Subject: Hume Battery Energy Storage System (SSD 10460) – Environmental Impact Statement

Thank you for your email dated 6 August 2020 seeking comments from the Biodiversity and Conservation Division (BCD) of the Department of Planning, Industry and Environment (the Department) about the Environmental Impact Statement (EIS) for the Hume Battery Energy Storage System (BESS).

ATTACHMENT A – BCD Assessment Summary for Hume Battery Energy Storage System Environmental Impact Statement (SSD 10460)

ATTACHMENT B – Detailed comments for Hume Battery Energy Storage System Environmental Impact Statement (SSD 10460)

Figure 4.2 Key Environmental constraints (from EIS, Appendix D, p 39)

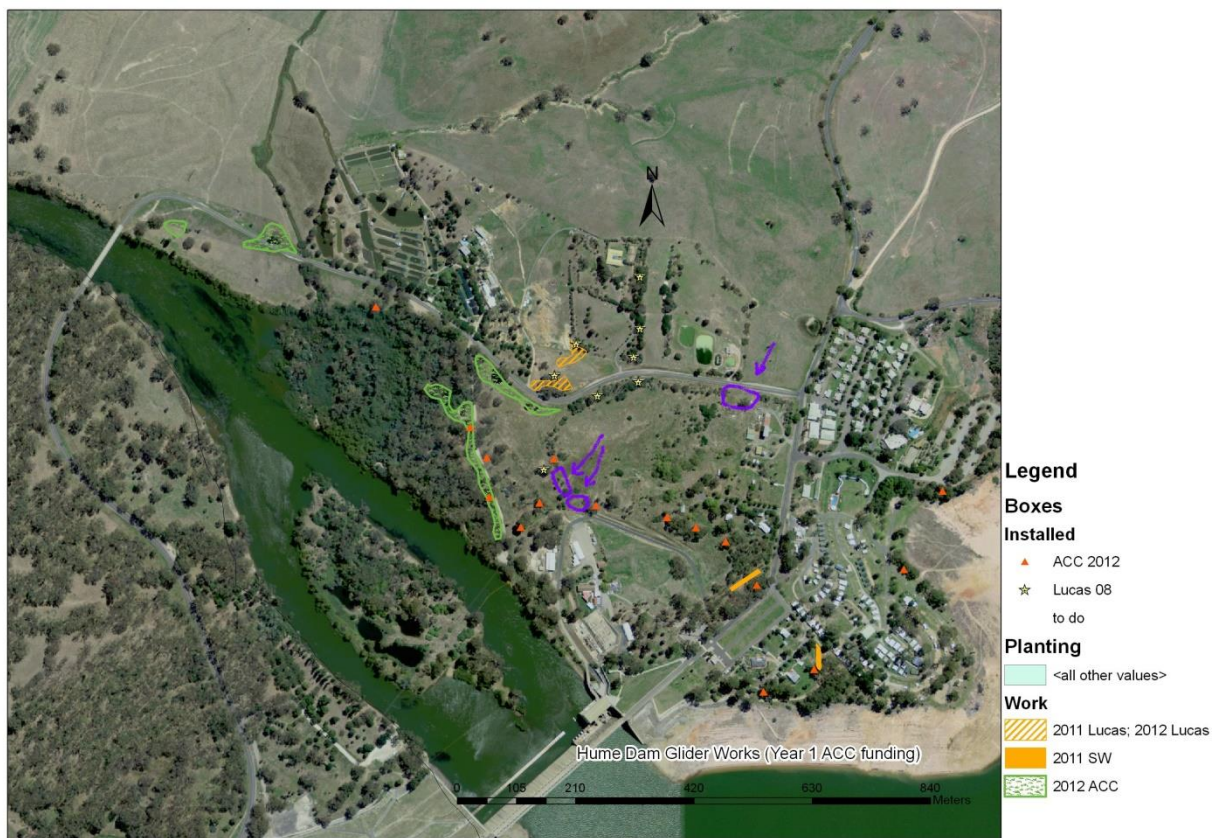
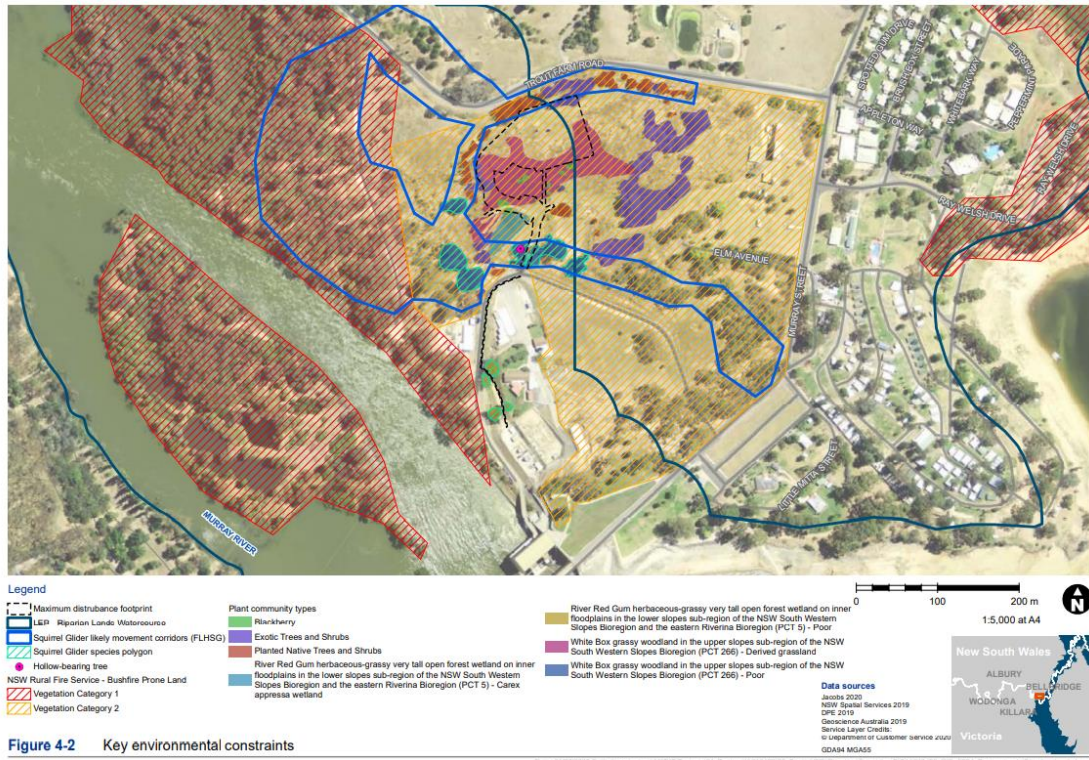
The vegetation on the unmapped part of the development footprint has not been described. It is not clear from aerial imagery how the boundary between this area and Zone 2 was determined. GIS data provided with the BDAR shows that BAM plot 4 is within the unmapped area. The floristic data in Appendix B indicates that Plot 4 includes native grass (*Themeda triandra*) with a cover of 5%.

The layout of the BDAR and mapped information about vegetation zones is confusing. It is difficult to work out how the plot data relate to the vegetation integrity and development footprint without a map of labelled plots. The maps of vegetation integrity plots should include individual plot identifiers. Floristic plots are usually mapped by a single point at the south-west corner. Figures 2-1 and 4-1 indicate that 10 vegetation integrity plots were sampled but there should be only one plot associated with each vegetation function mid-line.

The BDAR does not clearly map the vegetation zones to correspond with BAM-C. Please include the zone numbers on maps and explain early in the BDAR if and why there are zones that are not included in BAM-C – it is not until Section 4.2 (p 30) that the BDAR mentions that Zone 4 is not within the development footprint.

- *Provide more information about vegetation in the development footprint that has not been included in a vegetation zone. Explain how the boundary of Zone 2 was determined.*
- *Revise maps (Fig 2-1 and 4-1) to show BAM vegetation integrity plot location labelled with the plot identifier and vegetation zones numbered to correspond with BAM-C.*
